LOT SPLIT OF AUBURN PINES, LOT 29  
VICINITY OF  
AUBURN STREET AND 34 GARSOE DRIVE  
AMENDMENT TO AN APPROVED SUBDIVISION  
PHILIP AND CHARLENE JORDAN, APPLICANT

Submitted to:  
Portland Planning Board  
Portland, Maine

Submitted by:  
Bill Needelman, Senior Planner

Submitted on:  
October 6, 2006  
In support of the October 10, 2006  
Public Hearing

**Title:** AMENDED SUBDIVISION PLAN

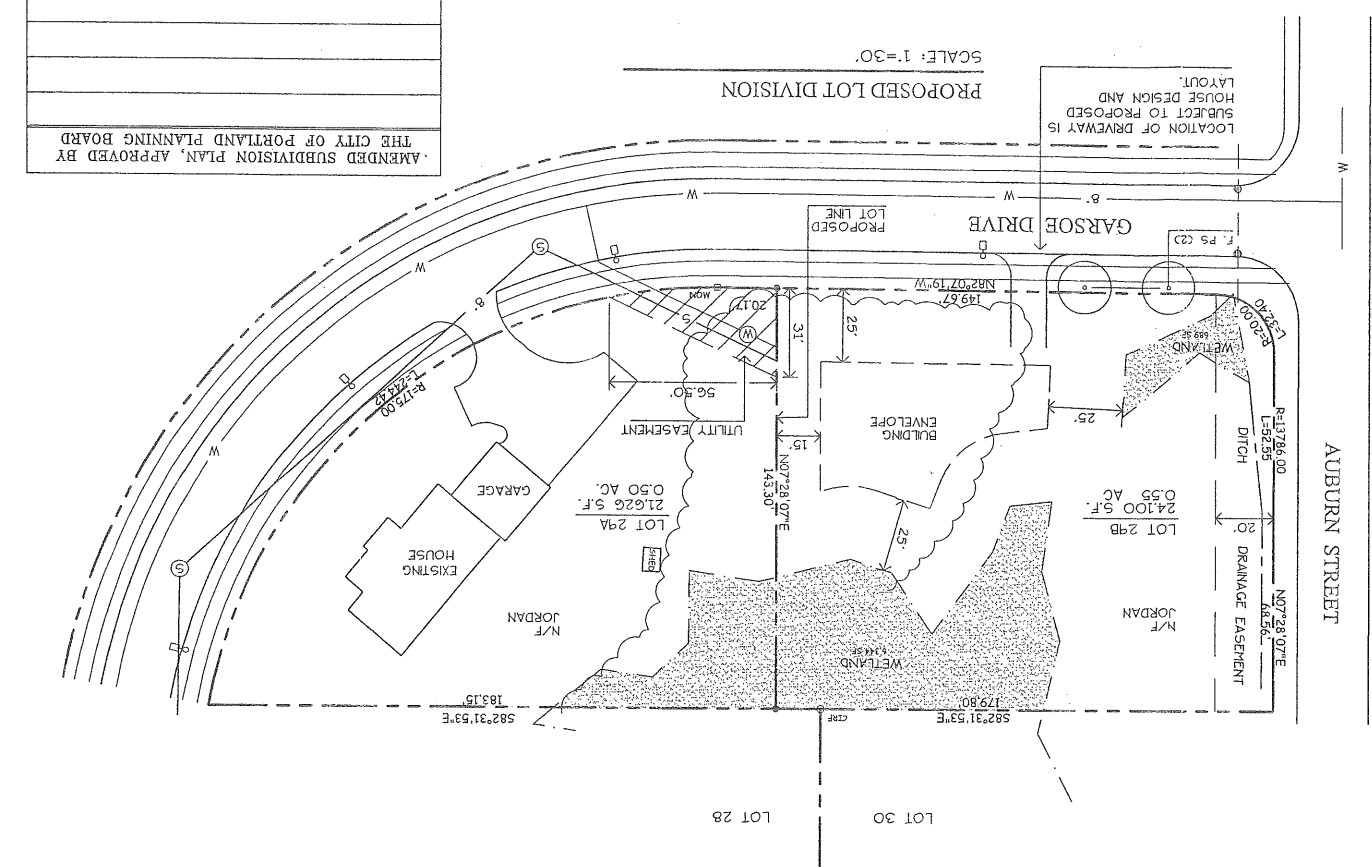
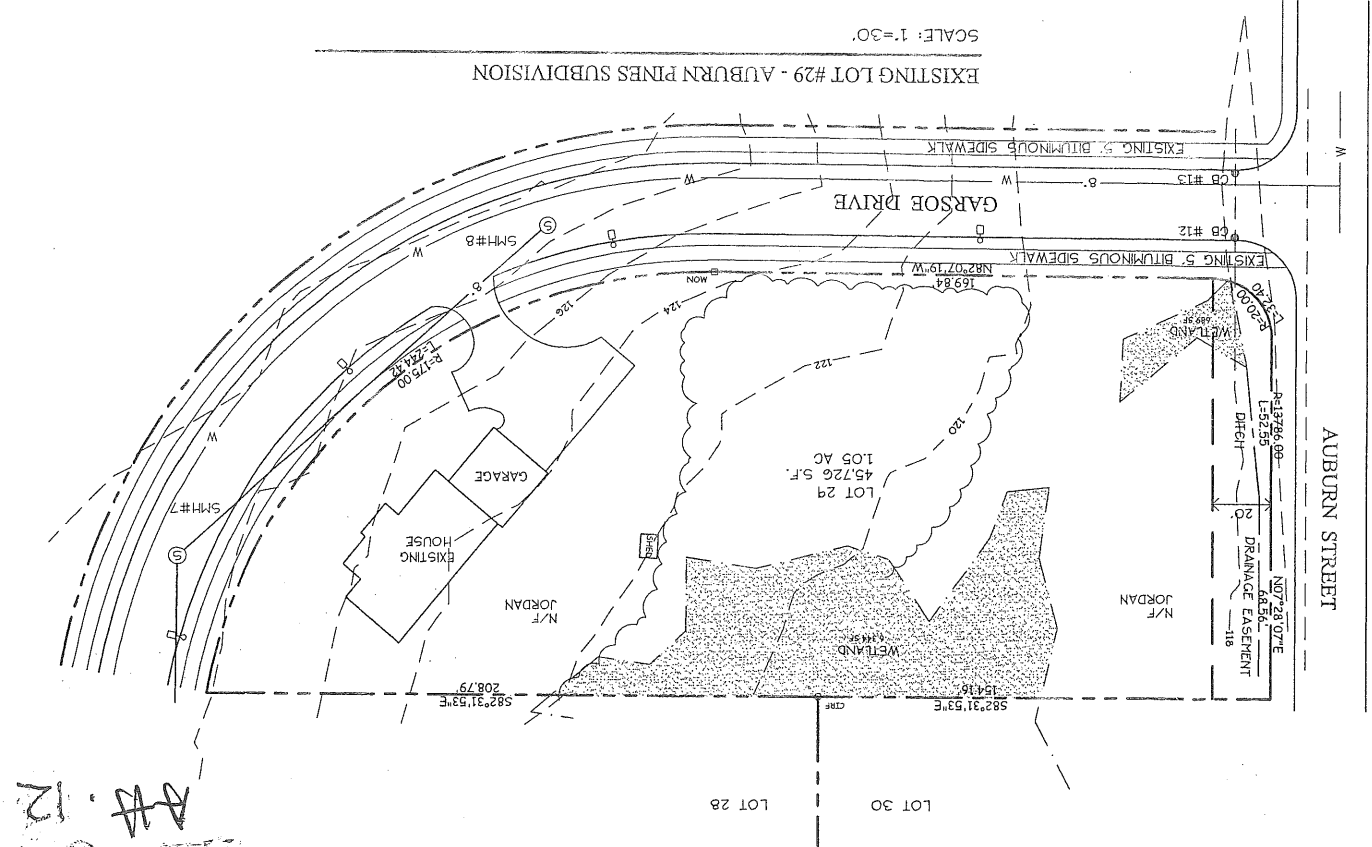
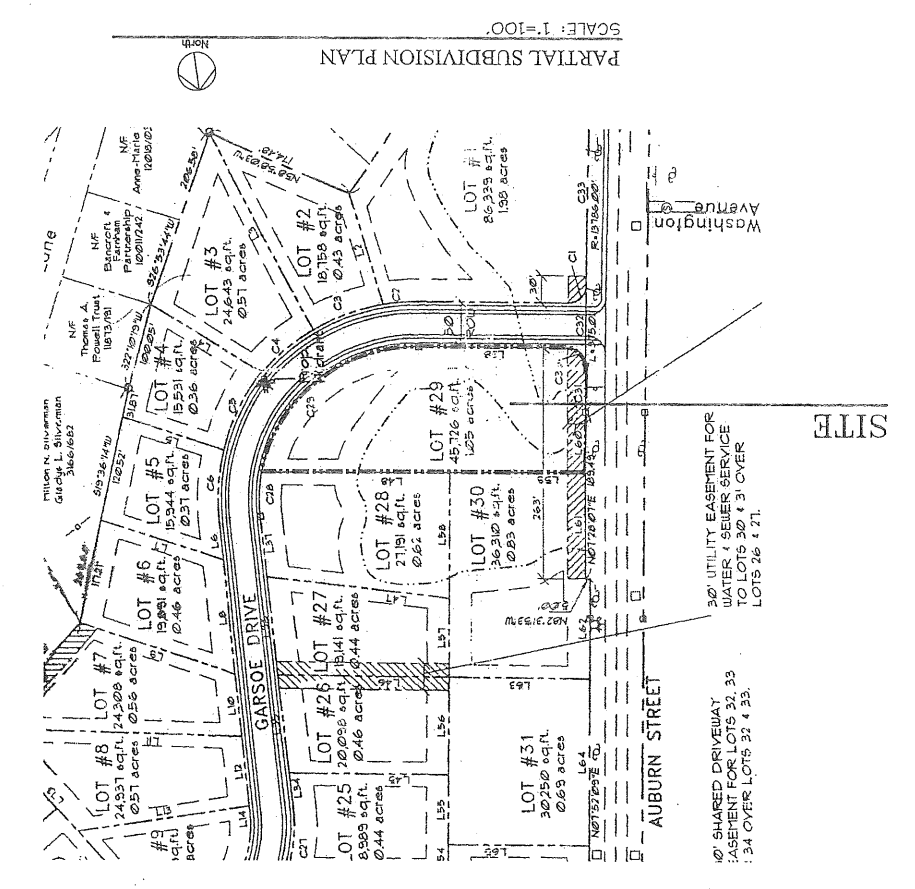
Lot 29A is shown having a private utility easement benefiting Lot 29B to allow connection to the existing utilities in Garsoe Drive without extending the existing sanitary sewer. Legal and Public Works Staff have reviewed this and find it acceptable. Public Works, however, requests a condition of approval that the lateral sewer connection be detailed to show a junction with the existing line outside of the manhole, as per City requirements.

- i. That the applicant provide a revised sewer connection detail for review and approval of the Public Works engineering staff.
